Case Officer: Imogen Hopkin

Applicant: Ms Lucy Coltman

Proposal: Variation of Condition 5 (cycle storage area) of 20/03023/F to re-site the bicycle storage to the front of the dwelling

DRAWING No:							
PROJECT	ORG	ZONE	LEVEL	TYPE	ROLE	NUMBER	REV
1010	FCA	XX	00	PL	A	0110	P06

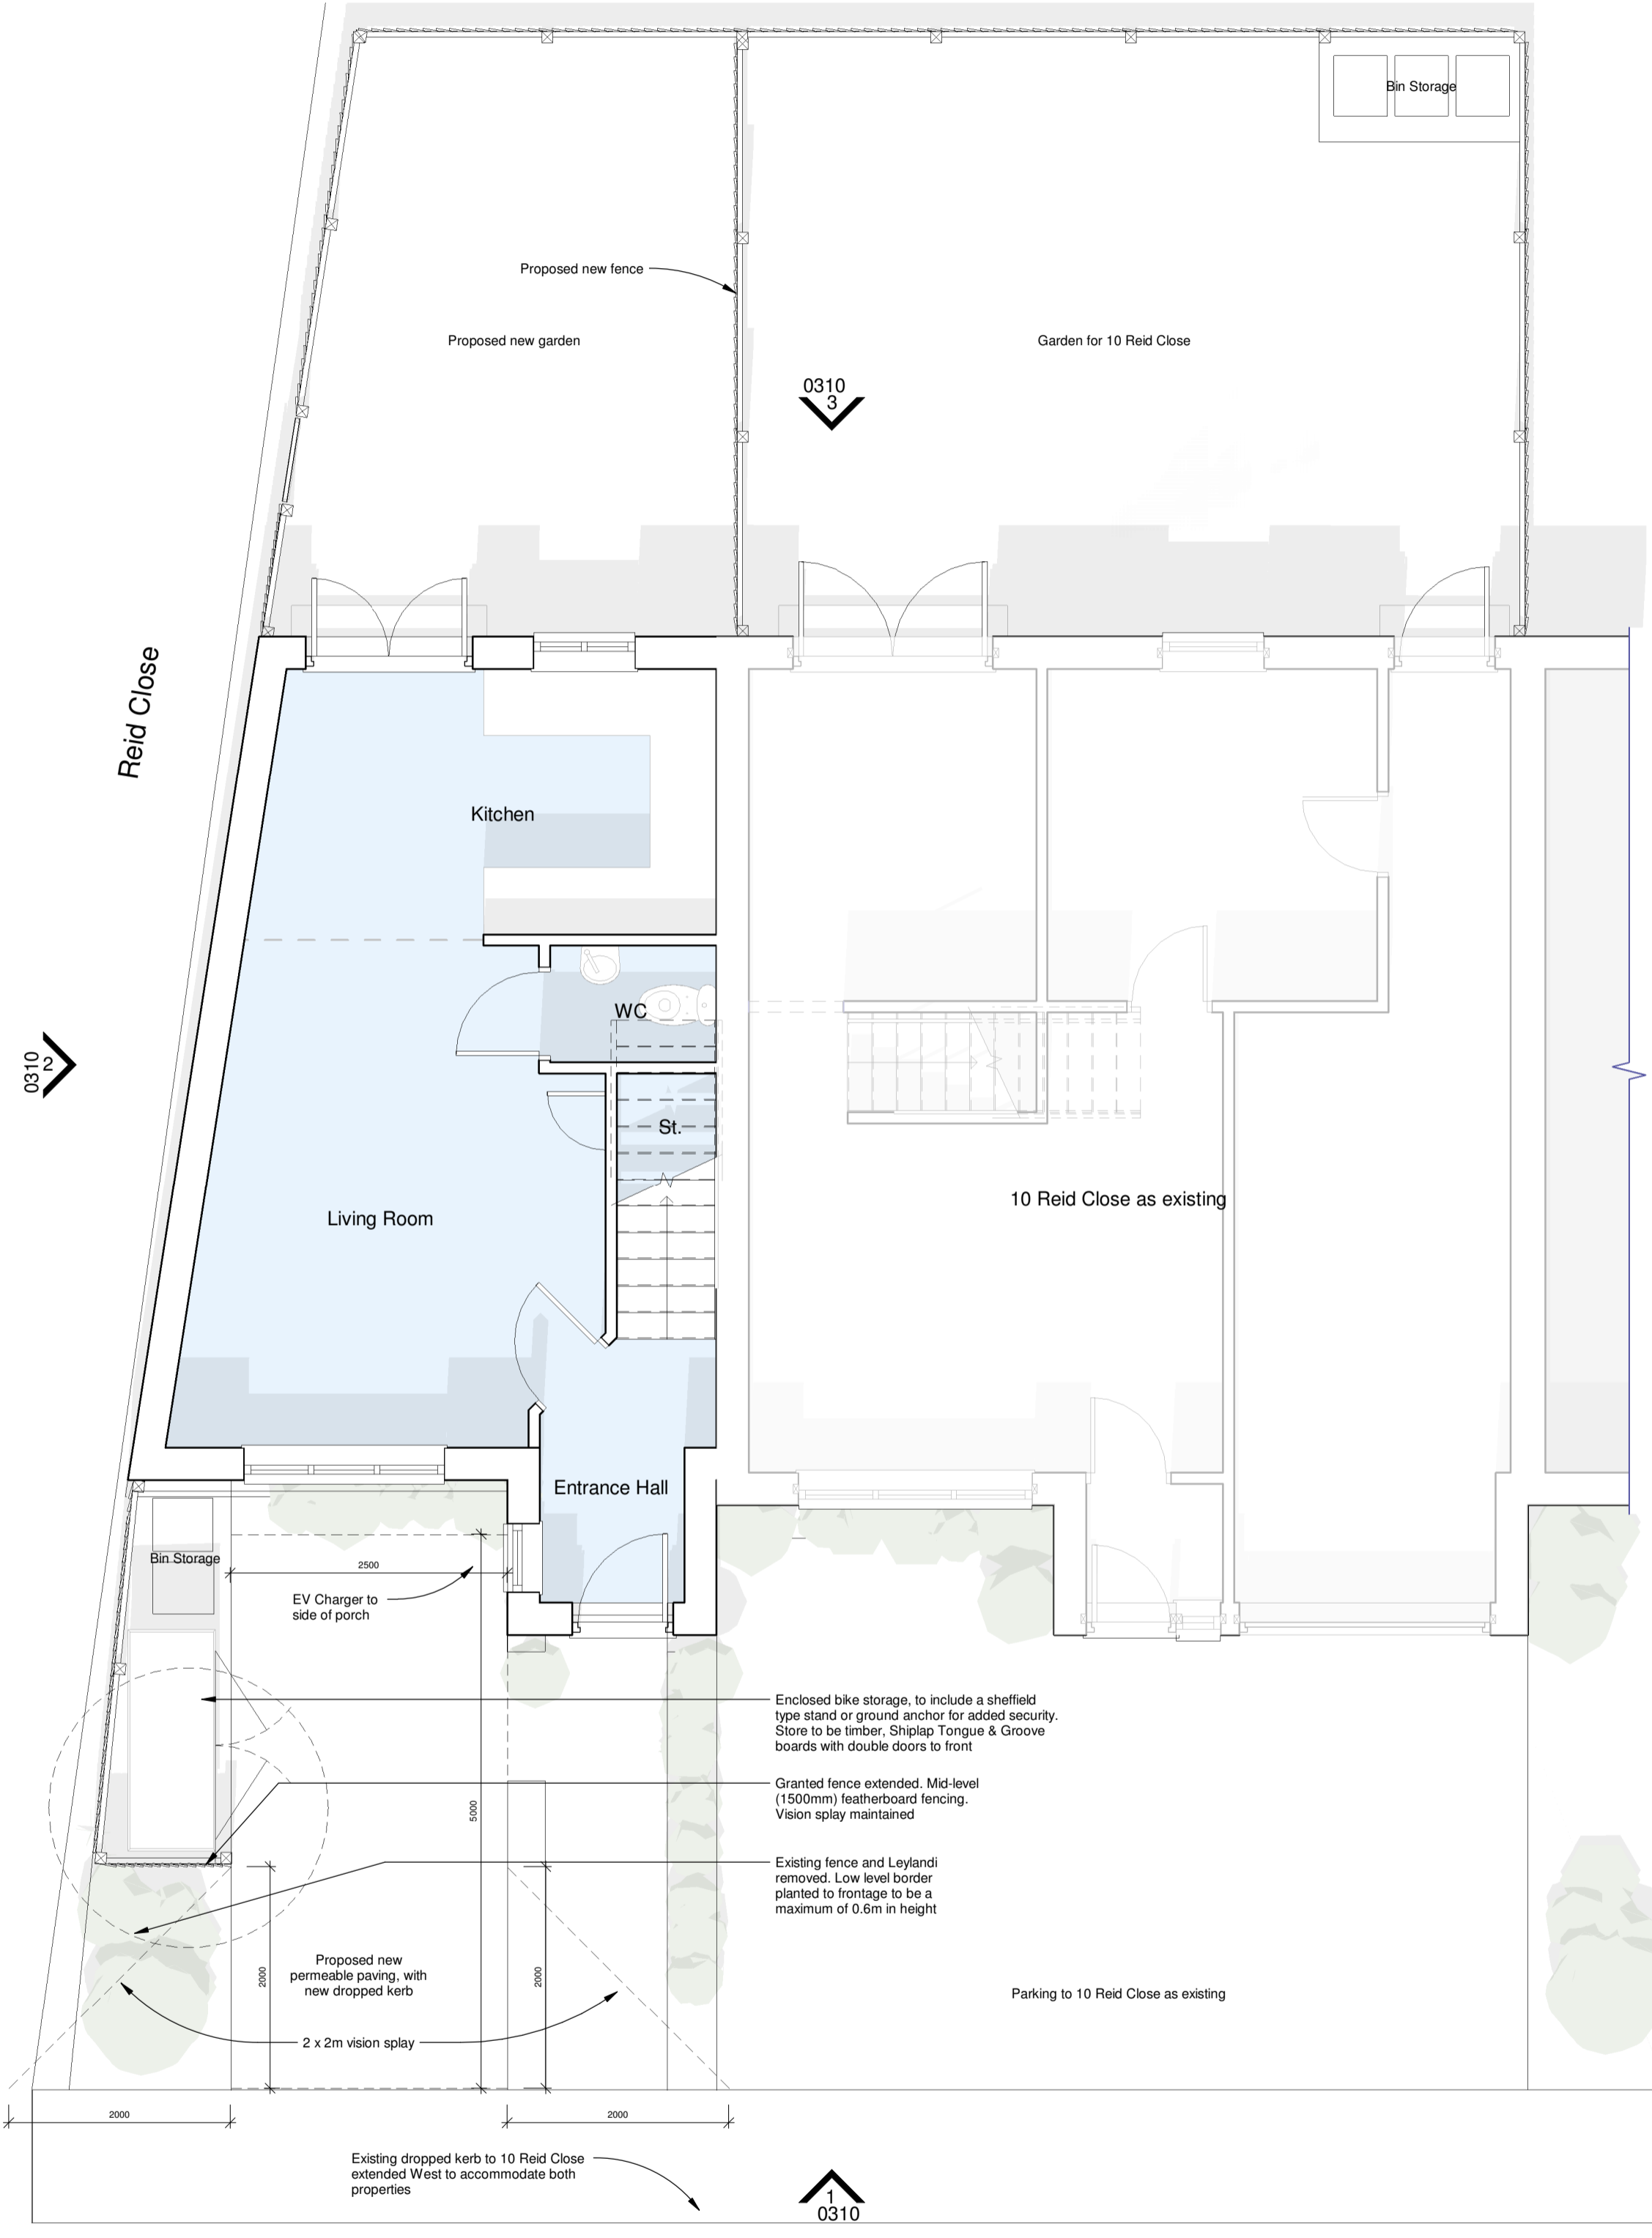
2.3. The application seeks to vary the condition to position the cycle parking to the front of the dwelling. This would include extending the partially enclosed area, which was originally designated for bin stores only. The height of featherboard fencing would be 1.5m, where it was previously approved at 1.35m, and would be sited 2m from the edge of the pavement, where previously it was around 2.8m from the edge of the pavement.

8.3. Generally speaking, structures to the front of a property are not acceptable, as they may interrupt the rhythm of a street scene and appear incongruous, and the cycle store would be sited close to the pavement. As mentioned, the height would be increased from 1.35m to 1.5m and the distance from the edge of the pavement decreased from 2.8m to 2m.

8.4. However, regard is had to the position of the proposed dwelling at the end of a cul-de-sac where, from Townsend to the south looking down Reid Close No. 10 is the vista stopper rather than the approved new dwelling. In addition, the proposed cycle storage would replace the structure previously approved as a bin storage area.

8.5. Further, the location of the cycle parking would be adjacent to the communal garages adjacent to the site.

8.6. Overall, therefore, the proposed cycle store would not appear unduly prominent within the street scene and, on balance, its revised position is considered acceptable.

5. The dwelling hereby approved shall not be occupied until space has been laid out within the site in accordance with drawing no. 1010 FCA XX ST PL A 0110/P06 and 1010 FCA XX ST PL A 0200/P01 for bicycles to be parked and that space shall thereafter be kept available for the parking of bicycles at all times.

PROJECT:	ORG:	ZONE:	LEVEL:	TYPE:	ROLE:	NUMBER:	REV:
1010	FCA	XX	XX	XX	A	0200	P01

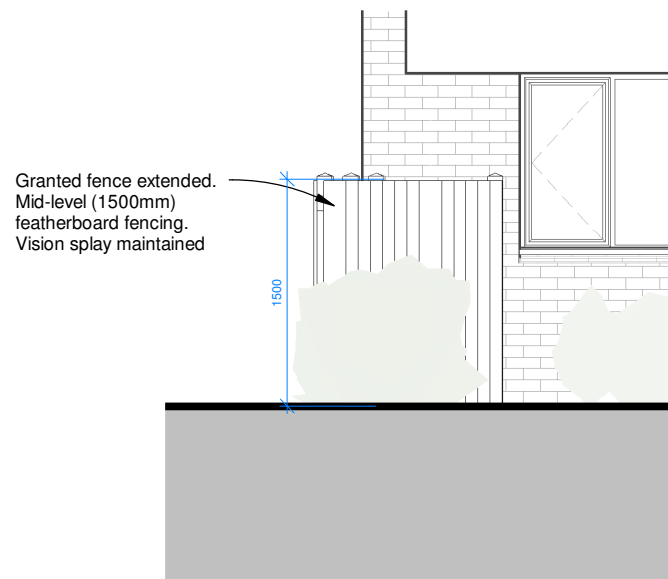
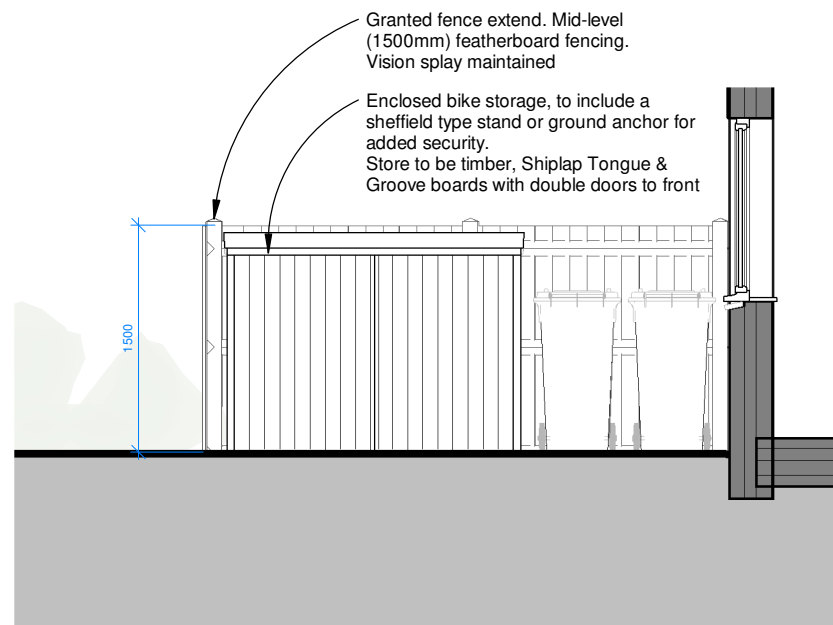
6.2. **Banbury Town Council:** Some concern about the appearance of this enclosed facility at the end of cul-de-sac location.
